17 May 2012

(Your Ref: MP10_0177 MOD 9)

**RE: COUNCIL SUBMISSION TO MP10_0177 MOD 9, AMENDED APPLICATION FOR
MODIFICATION OF MAJOR PROJECT APPROVAL UNDER SECTION 75W**

LEVEL 4 - FLOOR PLAN

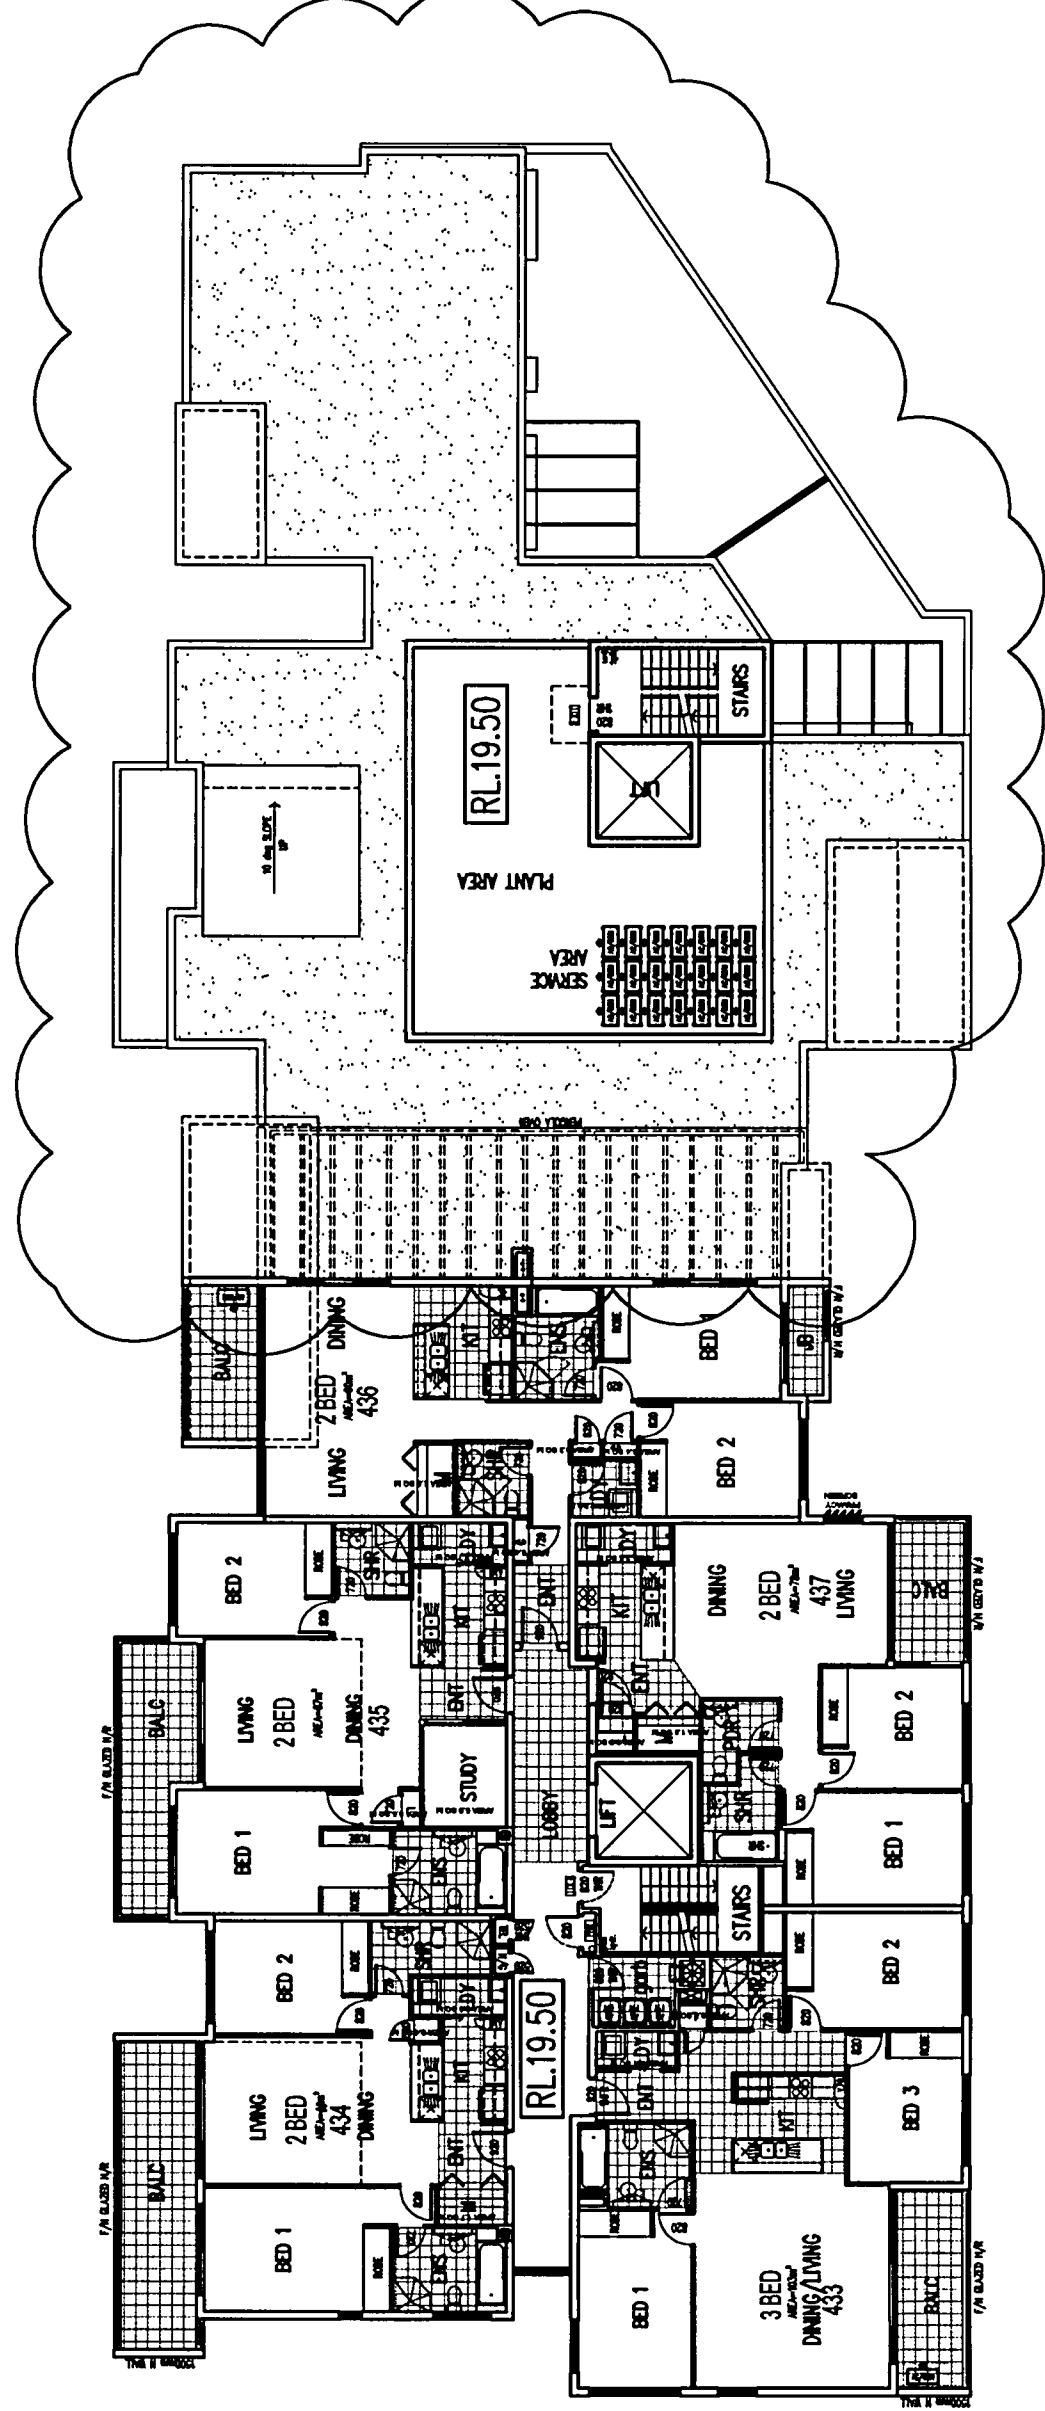
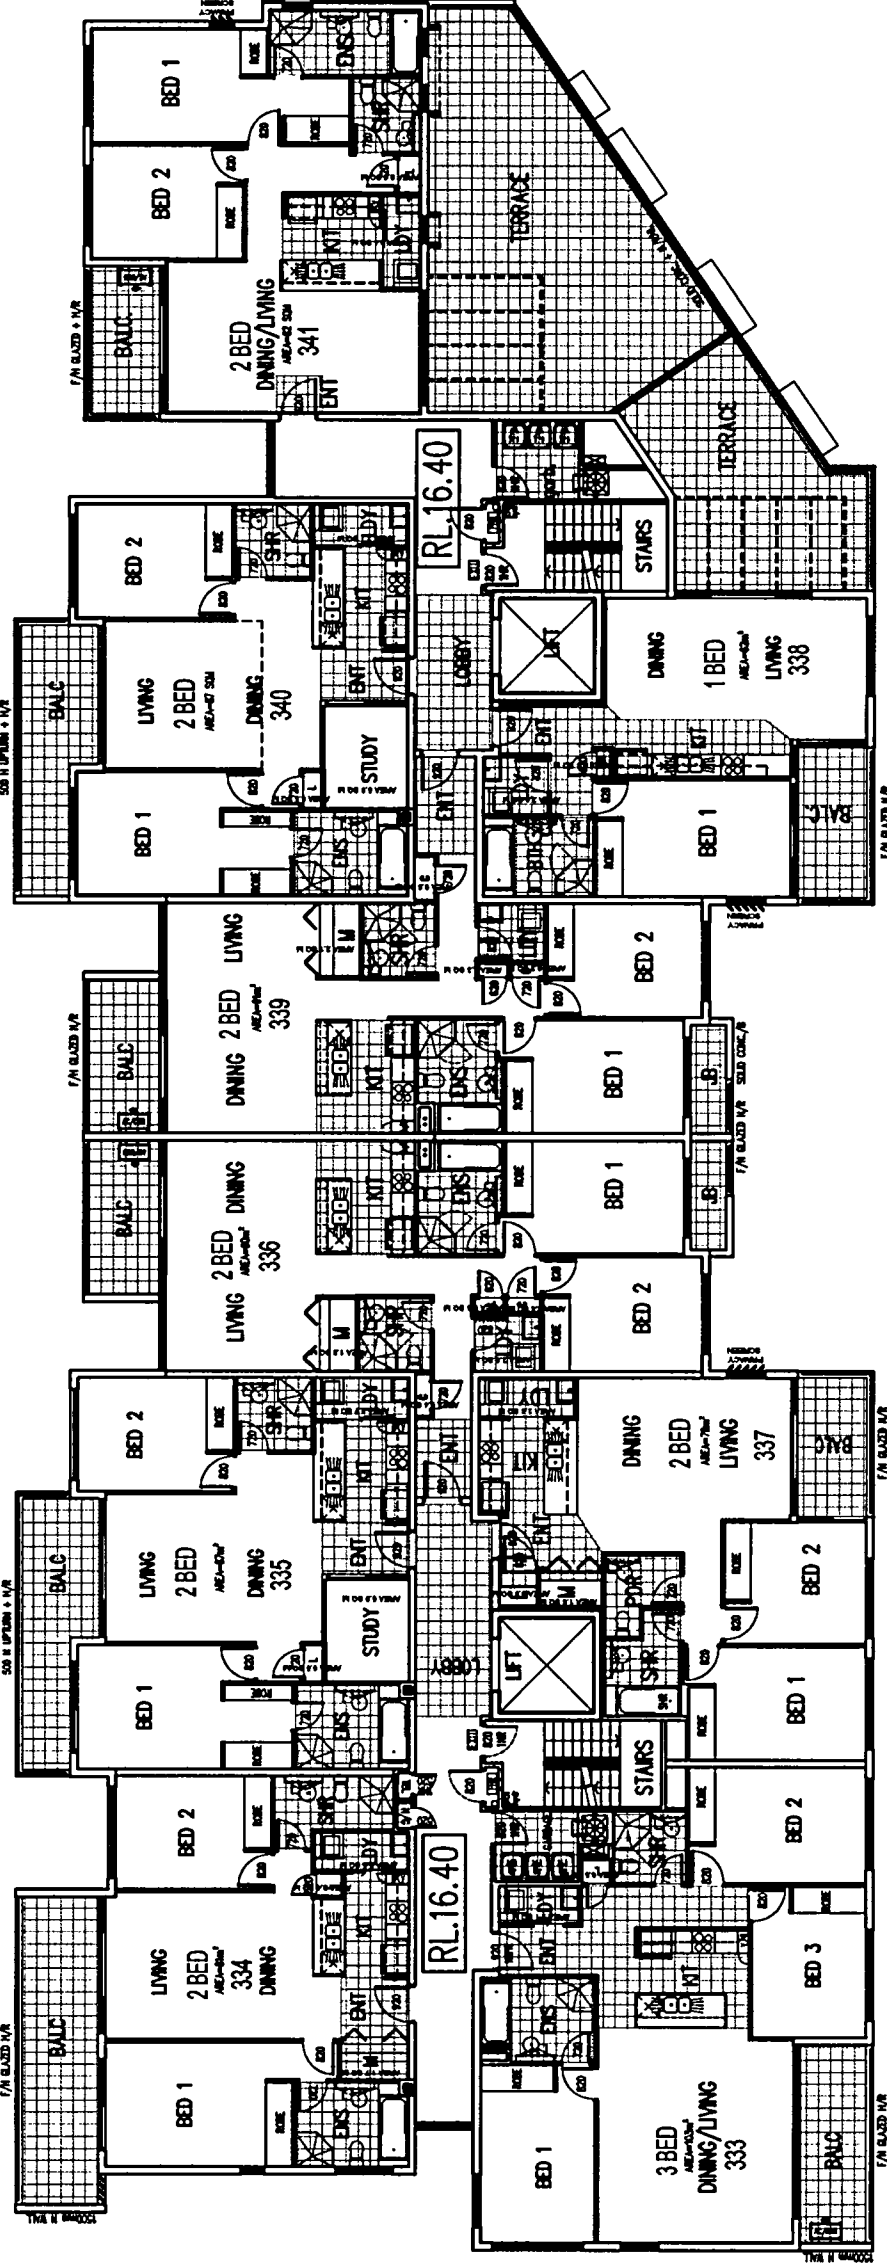
- The addition of separate studies to units 361, 361, G37, 236, 234, 136, 134, 330 and 335;
- Small adjustments to the layout of some units to accommodate the proposed studies. This consists of the relocation or realigning of kitchens, the relocation of the laundries and storage cupboards, and a revision of the window and door openings;
- The addition of two 'pop up' rooves above units 361 and 363;
- Insert a large storage cupboard into unit G34;
- Extend the cement slab that is at the roof level over the balcony of unit 330 to provide a roof for the balcony; and
- Alter the south facing windows in unit 331.

1. will not result in the study areas able to converted into additional bedrooms that in turn requires additional car parking spaces, and
2. in accordance with the BASIX Certification.
